NORTH FALLS OFFSHORE WIND FARM

Appendix B5 to the Natural England Deadline 5 Submission
Natural England's Marine Processes Advice on the Applicant's Deadline 4 Documents

Planning Inspectorate Reference EN010119

30 May 2025

Figure 3-1 - Disposal zone constraints

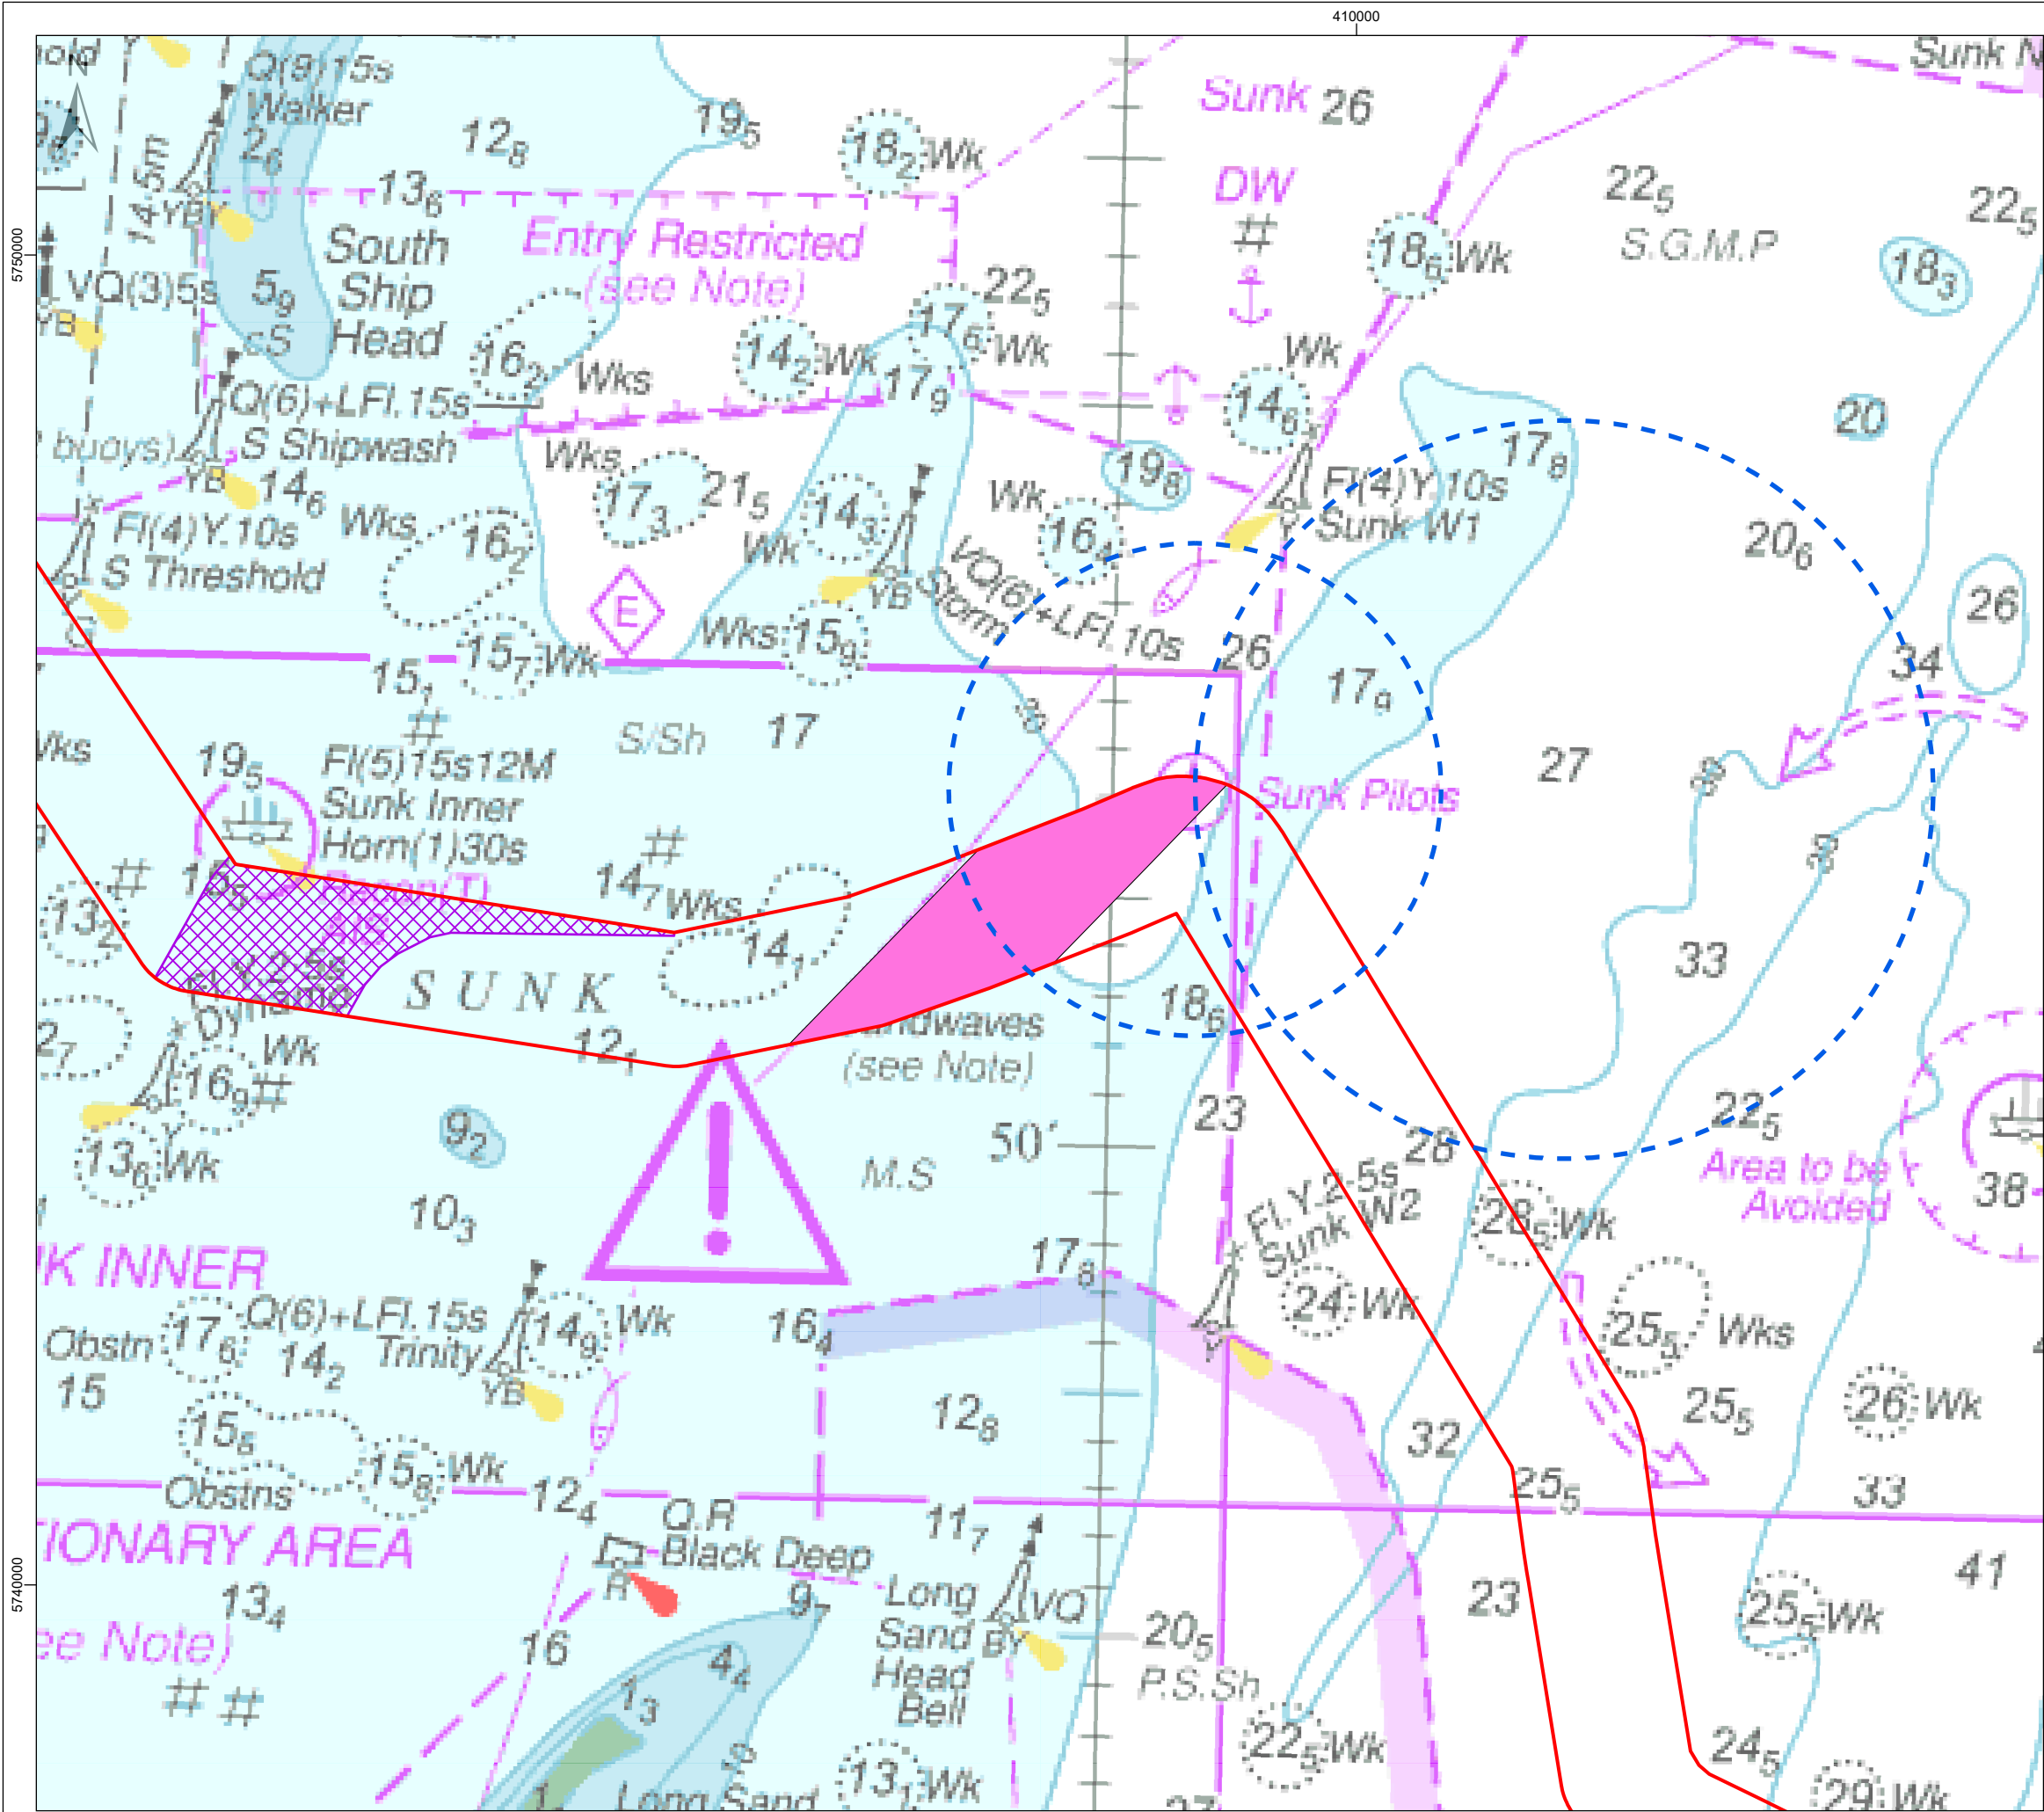
NE Ref	Section	Key Concern and/or Update	Natural England's Advice to Resolve Issue
1	3.3	Natural England notes that clay material produced from dredging the Deep Water Routes would need to be disposed within a different section of the disposal site including within the array area. This is estimated to have a volume of 304,917m ³ and a seabed footprint of 200,000m ² when deposited. It is stated that there will be no direct disturbance in the KKE MCZ. This has not been assessed for impacts to marine physical processes receptors.	As above, we advise that a constraint should be considered to avoid clay disposal near KKE MCZ. The WCS parameters for the disposed clay mound/s and persistence should also be provided. With preference given to disposal of sediment within similar sediment type, and avoidance of the formation of berms which could disrupt sediment transport.

Figure 1.1 Layout of the Project that has been modelled for changes to tidal current speeds and bed shear stresses

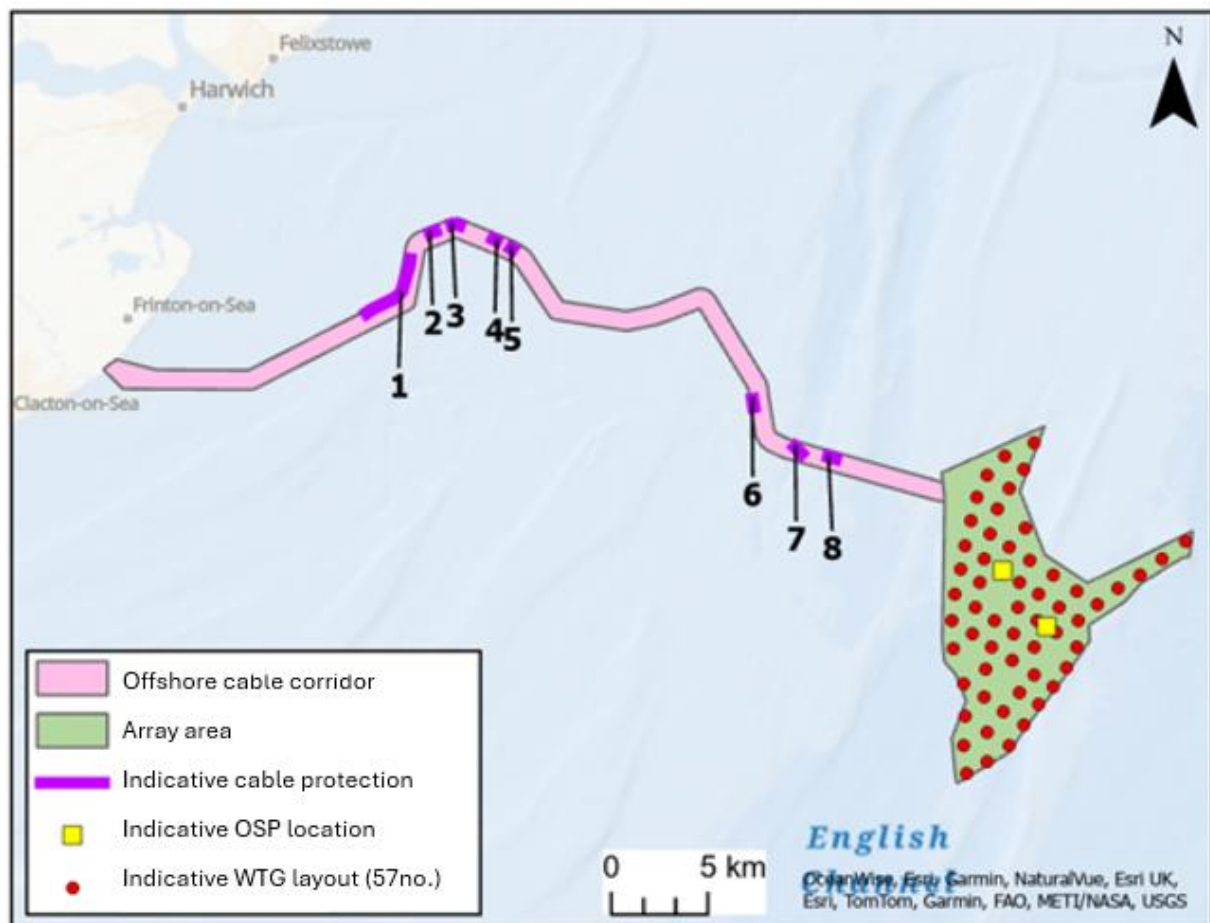
NE Ref	Section	Key Concern and/or Update	Natural England's Advice to Resolve Issue
1	General comment	Natural England welcomes the hydrodynamic and dispersion modelling carried out by the Applicant.	N/A
2	Table 5-2/5.2.4	<p>Natural England advises that it is not clear whether the model bathymetry resolution is sufficiently detailed to inform understanding of potential impacts to sediment transport patterns, seabed sediment composition and seabed morphology at key features such as Margate and Long Sands Special Area of Conservation (MLS SAC) or Kentish Knock East Marine Conservation Zone (KKE MCZ). For example, near-field effects that may extend from individual turbines to overlap with KKE MCZ, or that may extend from cable protection along the ECC, to overlap with the SAC.</p> <p>We also note that the tidal hydrodynamic model was run for the proposed windfarm</p>	<p>We advise that further information and/or clarification is needed to demonstrate that the model resolution is sufficiently detailed to adequately inform assessment of changes to hydrodynamic and sediment transport near/at the SAC and MCZ.</p> <p>We also advise that near-field effects should be evaluated and discussed, for example, wake effects that may extend from individual turbines into the KKE MCZ and cable protection blockage effects on sediment transport processes at MLS SAC.</p> <p>We also advise that the contribution of array cable protection measures to changes in tidal current speed and bed shear stresses should be considered.</p>

scenario with WTGs and OSP/OCPs included but not array cable protection. The contribution of array cable protection measures to predicted changes in tidal current speeds and bed shear stresses are not discussed.	
3	6.3.2 & Table 6-2	Whilst changes in bed shear stress have been presented, Natural England notes that the baseline absolute bed shear stresses have not been presented. Moreover, the predicted bed shear stress changes have not been assessed against the threshold for sediment movement for the different sediment fractions at the key areas of interest (e.g. SAC, MCZ, offshore sandbanks). Natural England advises this information is needed to inform understanding of potential changes to deposition and erosion rates, seabed morphology, and seabed sediment composition due to the proposed development.	We advise that the modelled changes in bed shear stress need to be presented/considered relative to baseline absolute bed shear stresses and the threshold for sediment movement for different sediment fractions. Furthermore, the predicted changes in bed shear stress need to be evaluated in terms of impacts on erosional and depositional processes near and on the seabed, seabed morphology, and seabed sediment composition at the key areas of interest (e.g. KKE MCZ, MLS SAC, offshore sandbanks etc.).
